Item No. **Report of the Head of Planning, Sport and Green Spaces**

Address 67 HIGH ROAD ICKENHAM

Development: Part two storey, part single storey rear extension and two storey side extension

LBH Ref Nos: **8568/APP/2014/4086**

TITLE: House extension on ground and first floor	
PROJECT: Proposed plans	
CLIENT: Mr Pard Gosal	
PLACE: 67 High Road Ickenham UB10 8LQ	
ARCHITECT ALEXANDRE MIGUEL MARQUES DURÃO RIBA Registration No: 20011737 ARB Registration No: 077740D	
SCALE: 1:100	DATE: November 2014
Drawing Number

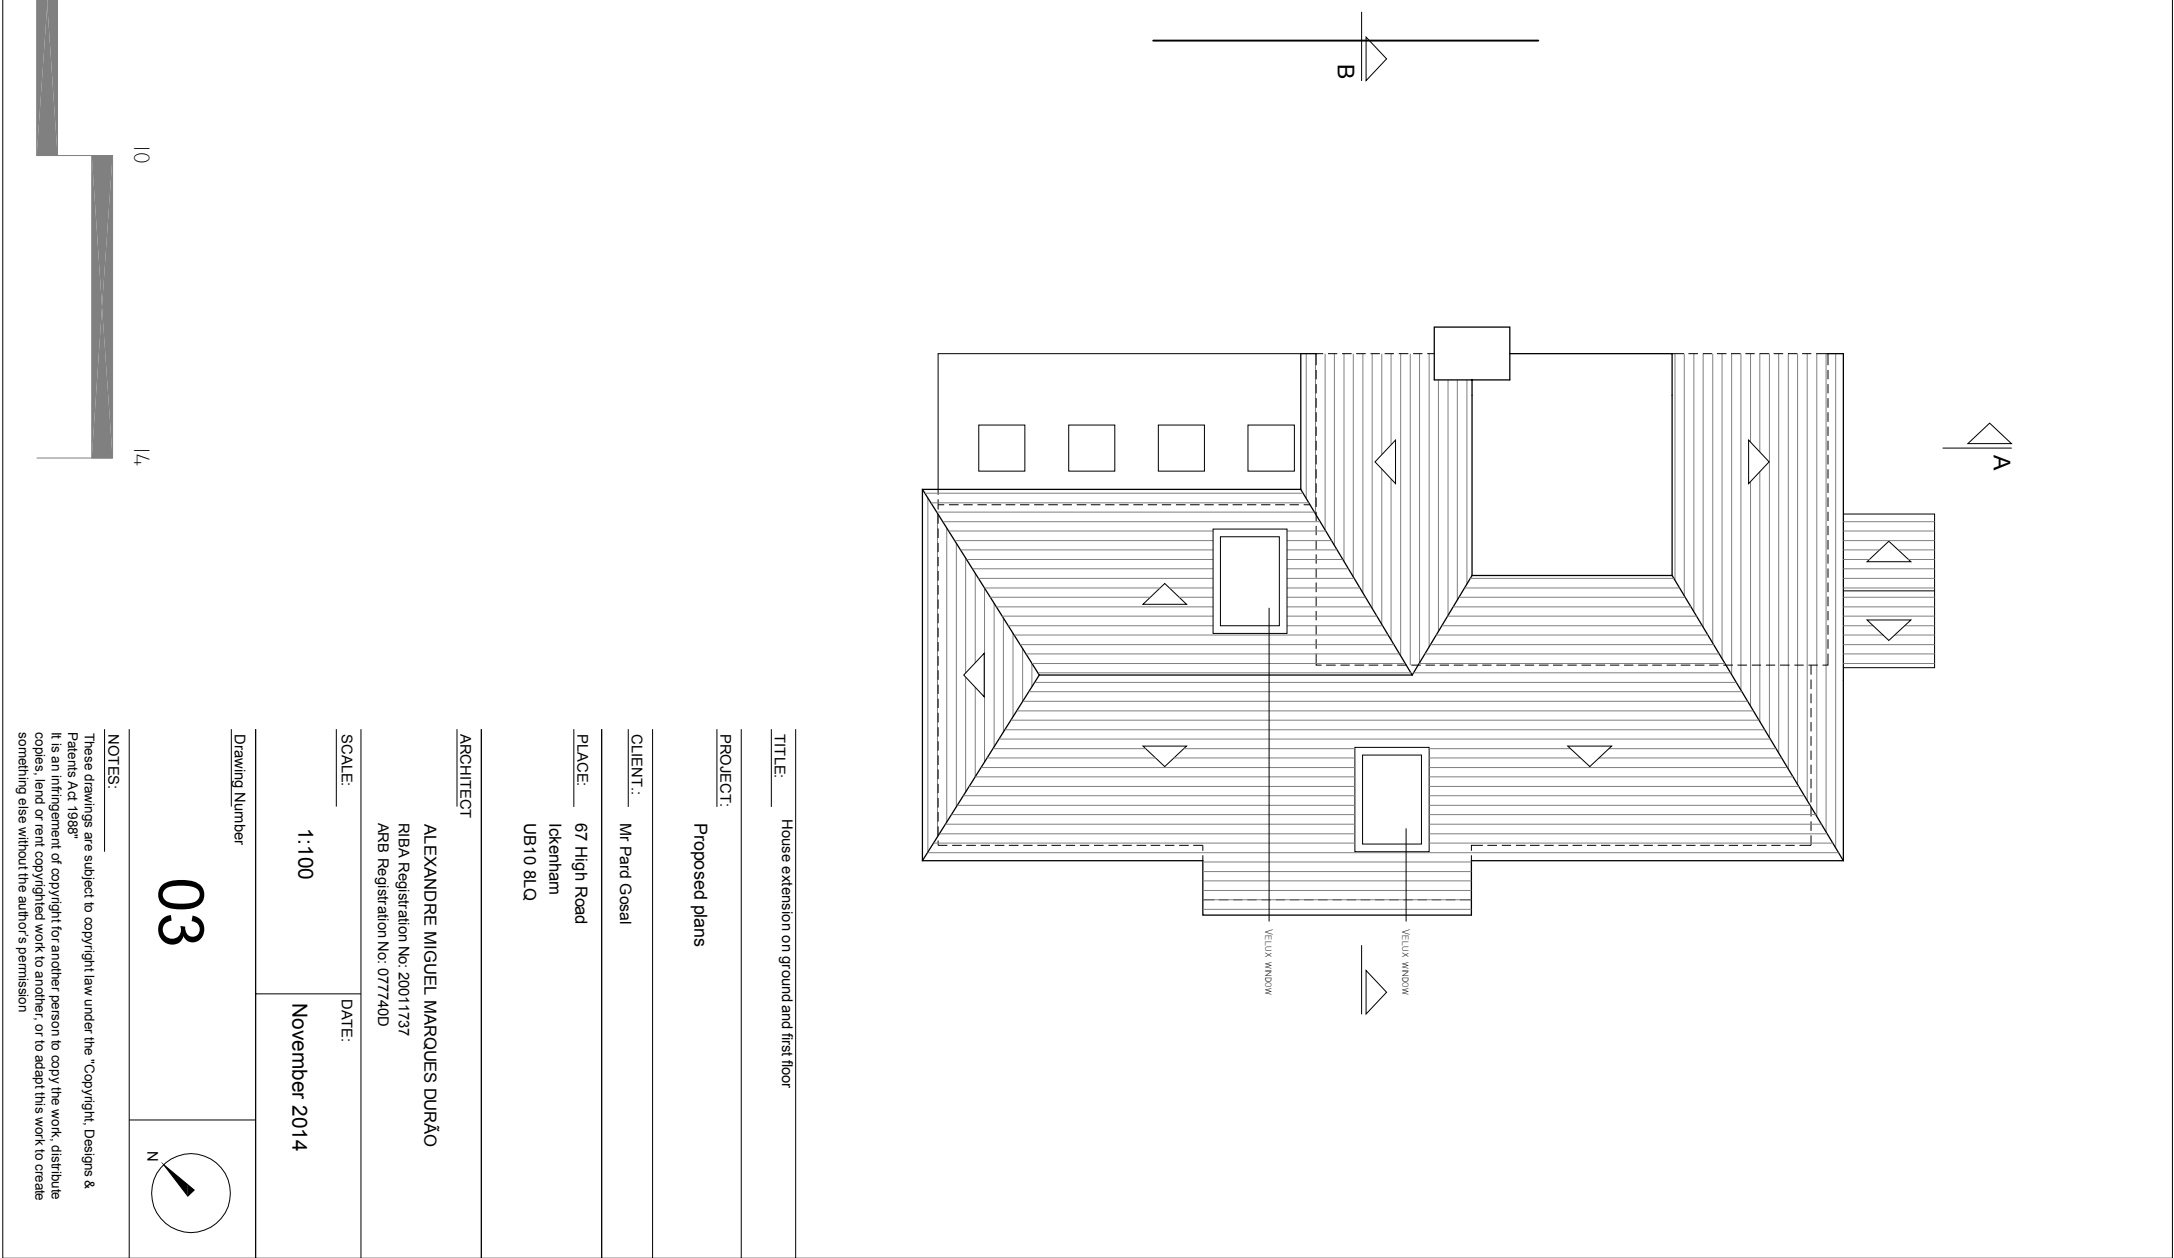
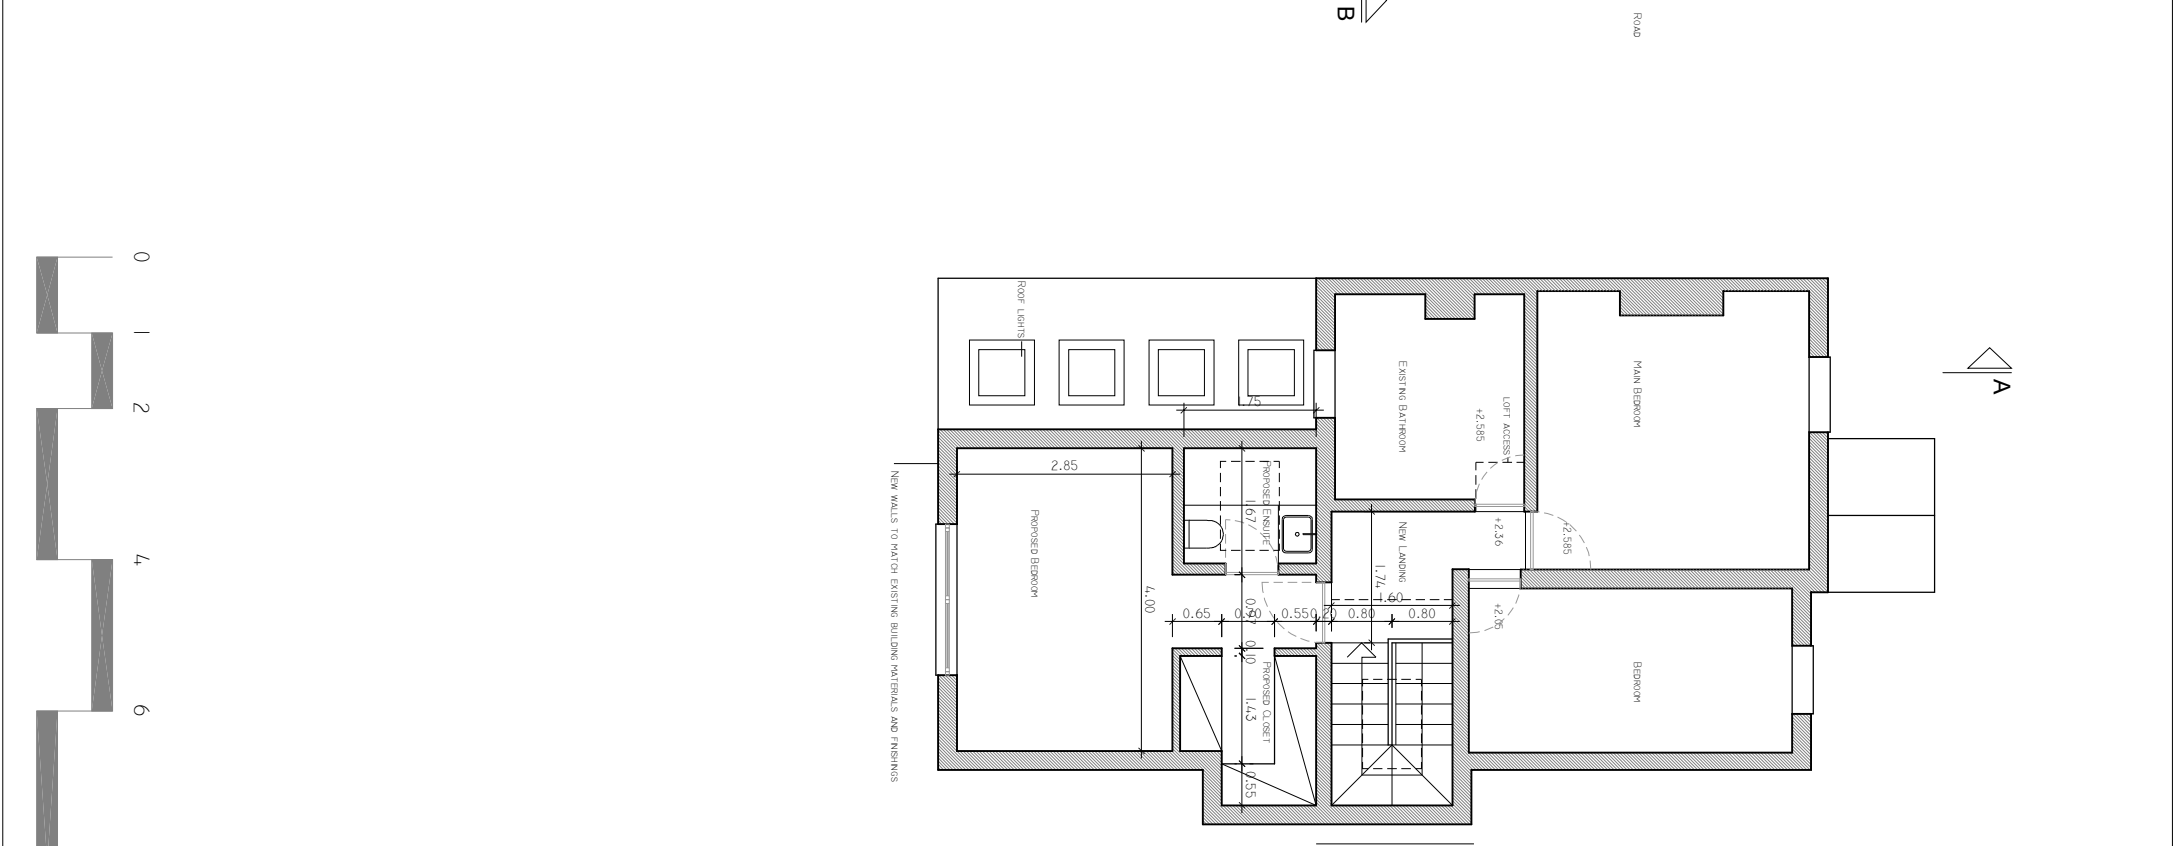
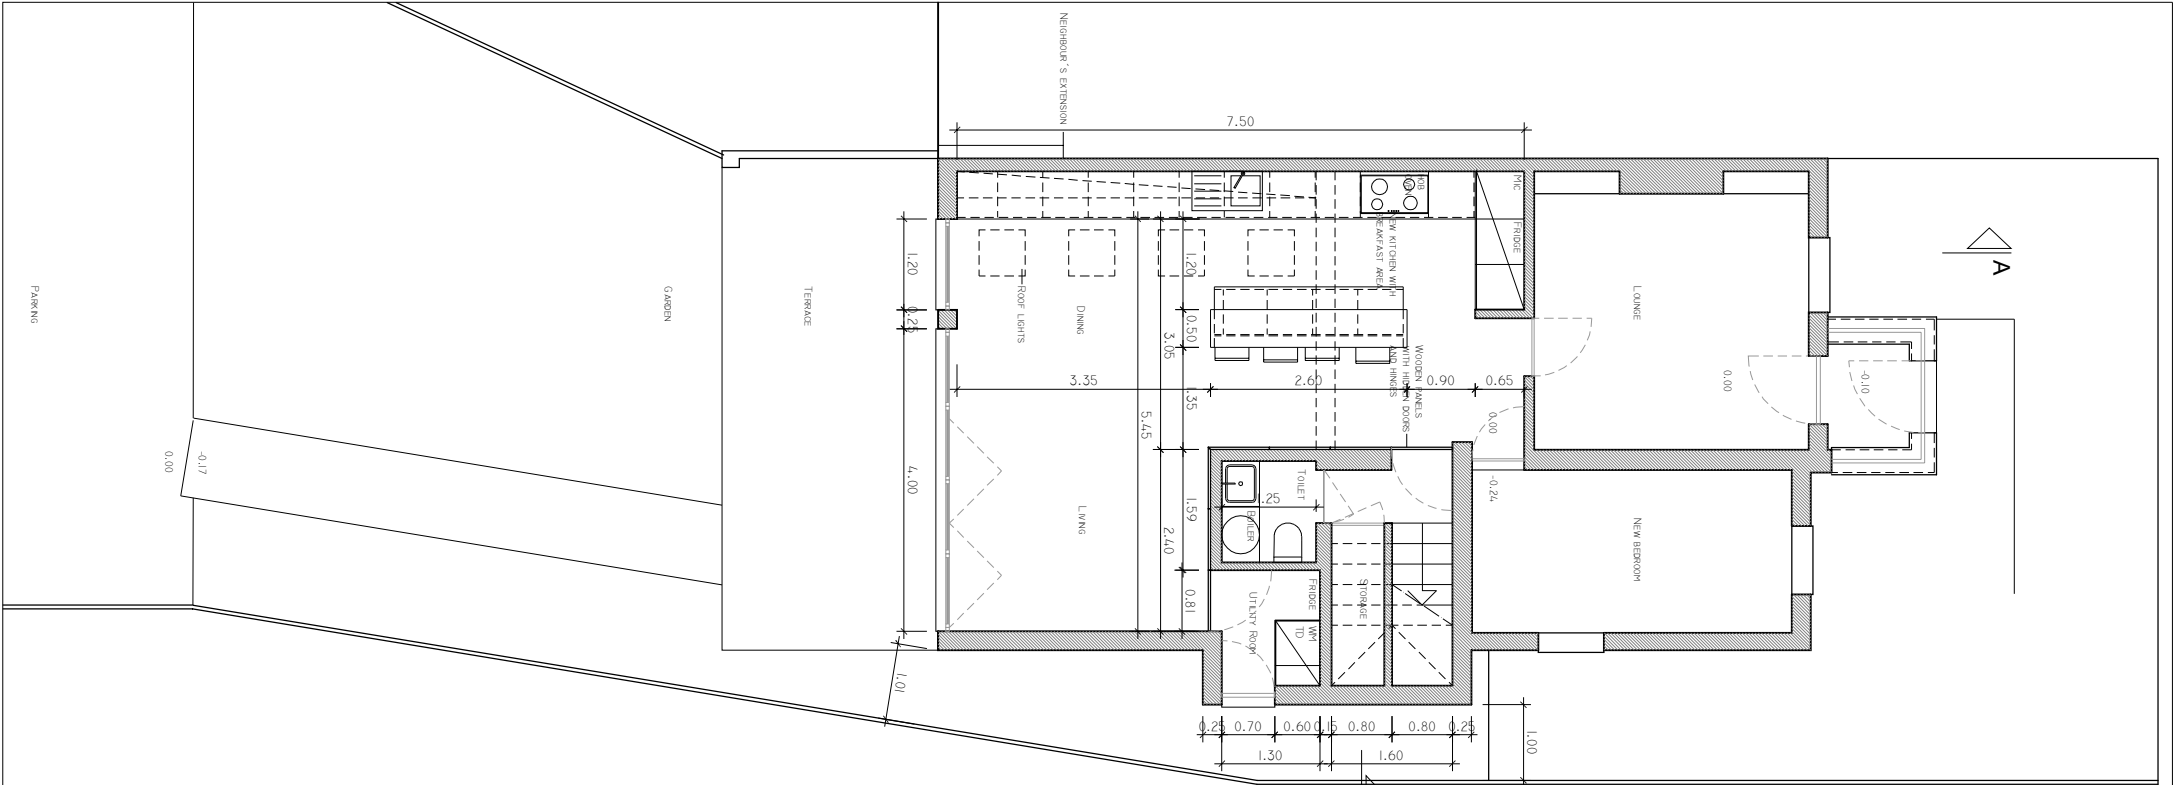
There would be no objection in principle to the proposed single storey rear extension; however the depth would need to be reduced to a maximum depth of 4m from the property's original rear building line, in accordance with council HDAS guidance.

- The proposed fenestration to the rear would not be in keeping with the existing property. This would need to be revised to sash style windows and doors, to match the original property.

- The proposed roof lights to the single storey rear extension would be considered incongruous additions, creating a cluttered roofscape. Therefore the number of roof lights would need to be significantly reduced. A proposed flat roof to the rear would need to be finished with a brick on edge parapet.

- The two storey side extension as designed would be detrimental to the character of the original property. The design of the side addition would considerably alter the symmetry of the pair of properties. The proposed two storey side extension should remain as a lean-to side wing maintaining the symmetry of the properties and not step out towards to rear of the property.

- The part two storey rear extension would not be in keeping to the plan form of the original property. As proposed it creates a wrap around over dominant element, which would be highly visible from the main road and neighbouring public house.

Paragraph 6.4 of the HDAS Residential Extensions guidance, states: First floor rear extensions should always be designed as to appear subordinate to the original house. Extensions to semi-detached houses on a plot more than 5m wide should not exceed 3.6m in depth. The proposed first rear extension would have a depth of 5m, which is contrary to the above guidance. Furthermore, with a width of 4.5m the proposal would occupy the majority of the rear elevation of the existing dwelling, forming an overdominant development that would fail to appear as a subordinate addition.

The proposed first floor side extension would be attached to the rear of the existing side extension at the property. However, the new addition would project 0.7m beyond the side elevation of the existing development forming a discordant and incongruous addition that would give the property at disjointed appearance. The impact of the side extension to the appearance of the surrounding area is exacerbated by its high visibility from the front of the dwelling and the public highway.

The proposed development also includes the creation of a crown profile which would not only significantly increase the size and bulk of the existing dwelling but would further unbalance the symmetrical appearance of this pair of semi-detached dwellings, to the

At 5m the proposed extension would exceed the maximum depth of 3.6m permitted for first floor rear extensions in the HDAS guidance. Its width would occupy the majority of the rear elevation of the existing property and would be built in close proximity to the shared boundary line with 69 High Road. As a result, the size, scale, bulk and rearward projection of the proposal is considered to form an overdominant addition that would breach the 45 degree line of sight taken from the nearest habitable window of the neighbouring property, causing an undue loss of residential amenity to the occupiers of the dwelling in terms of loss of light, outlook and overshadowing. Therefore the proposed development is contrary to Policies BE13, BE15 and BE19 of the Hillingdon Local Plan: Part Two - Saved UDP Policies (November 2012).
